**CONSTRUCTION OF 30 NO. DWELLINGS TOGETHER WITH ASSOCIATED ACCESS,
PARKING, PUBLIC OPEN SPACE & LANDSCAPING**

LAND AT WEST WALBERTON LANE, WALBERTON, BN18 0QF

Environment Agency Position

In the absence of an acceptable flood risk assessment (FRA) we **object** to this application and recommend that planning permission is refused.

SOUTHAMPTON
PROJECT NO.
A117709
DRAWING NO.
220
REV.
B

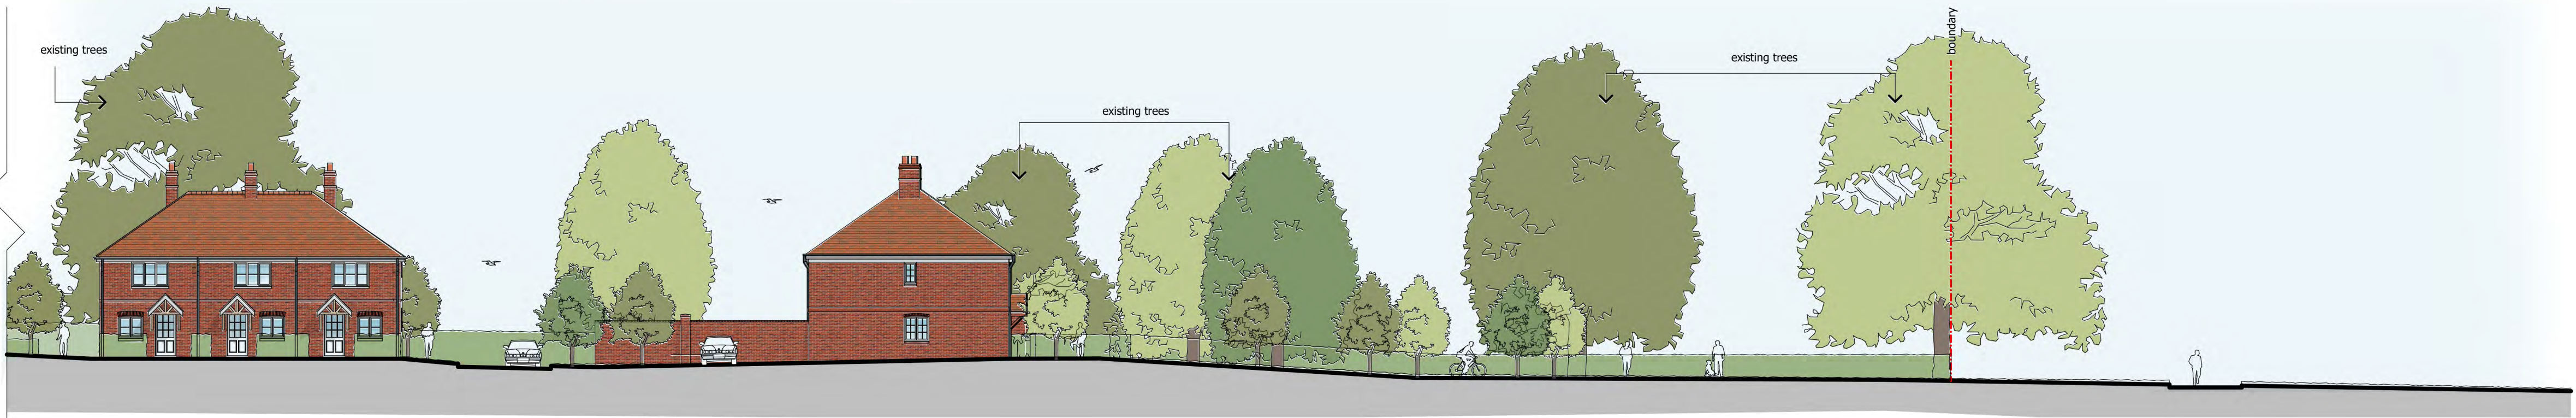
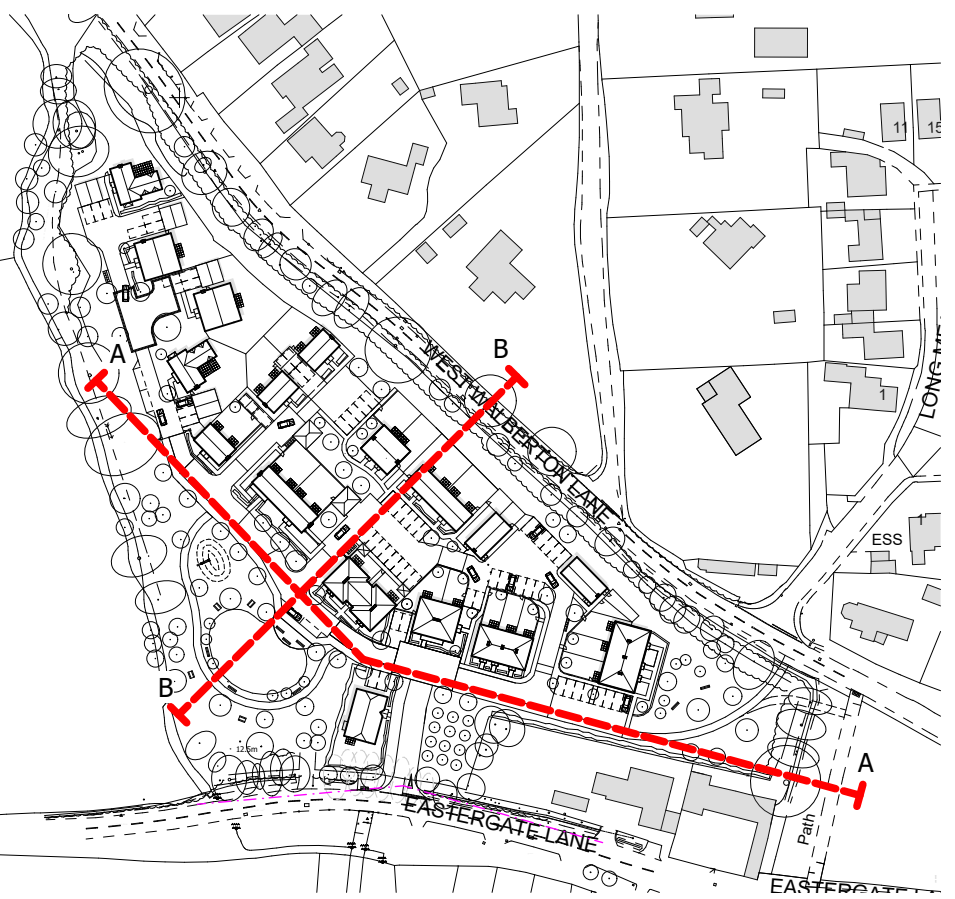
- The submitted FRA makes no mention of floodplain storage loss despite several drawings (including; drainage layout 1&2 and proposed site sections 220B) suggesting that there may be partial land raising for access roads and/or residential units. Compensation must be provided for any floodplain storage loss. Please provide post development ground levels and calculations for any compensation provided. There is a history of flooding downstream of the site on Barnham Lane and any floodplain storage loss is likely to increase the risk of flooding.

To overcome our objection, the applicant should submit a revised FRA which addresses the points highlighted above.
